Application No.	2021/93254
Proposed Development:	Erection of single storey rear and two storey side extension
Location:	52, Virginia Road, Marsh, Huddersfield, HD3 4AZ
OS Map Reference	SE 412235.5695 417199.3895
Applicant/Agent:	architectural drafting services
Class:	Other Developments

**Consultation Response from KC,
Trees****2021/93254 52, Virginia Road, Marsh, Huddersfield, HD3 4AZ****Erection of single storey rear and two storey side extension****Date Responded:
17/09/2021****Responding Officer: NG****Responding Ref: TPO 20/85**

PROPOSED SITE BLOCK PLAN
SCALE 1:200@A1

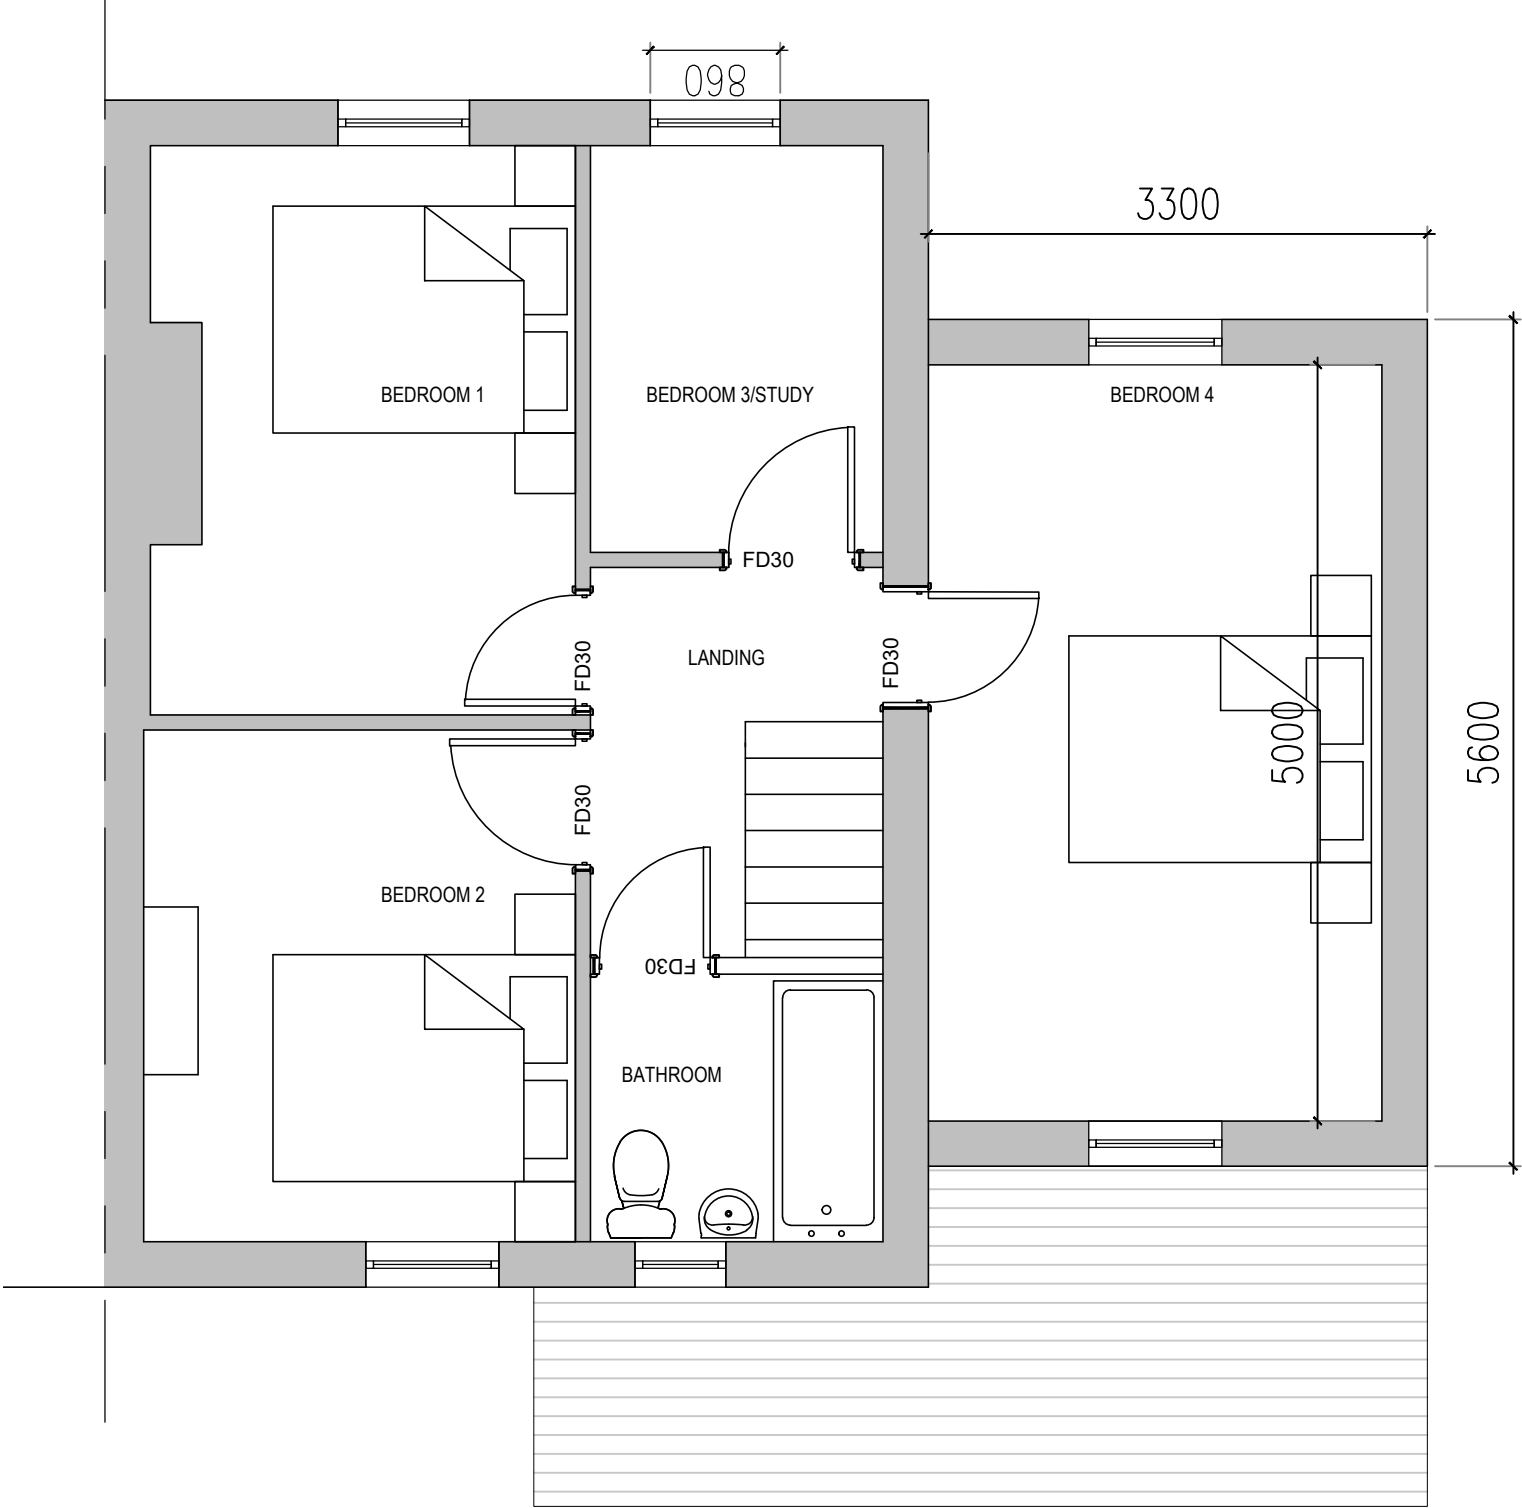
The property has a protected tree in the rear garden covered by tree preservation order, ref 20/85/T1. The proposals are for a side extension and single storey rear, neither of which will significantly impact on the adjacent tree. The proposals for the extension to the rear will bring the property closer to the tree canopy however there is sufficient clearance and room to accommodate this.

Given the above I would have no objection to the proposals.
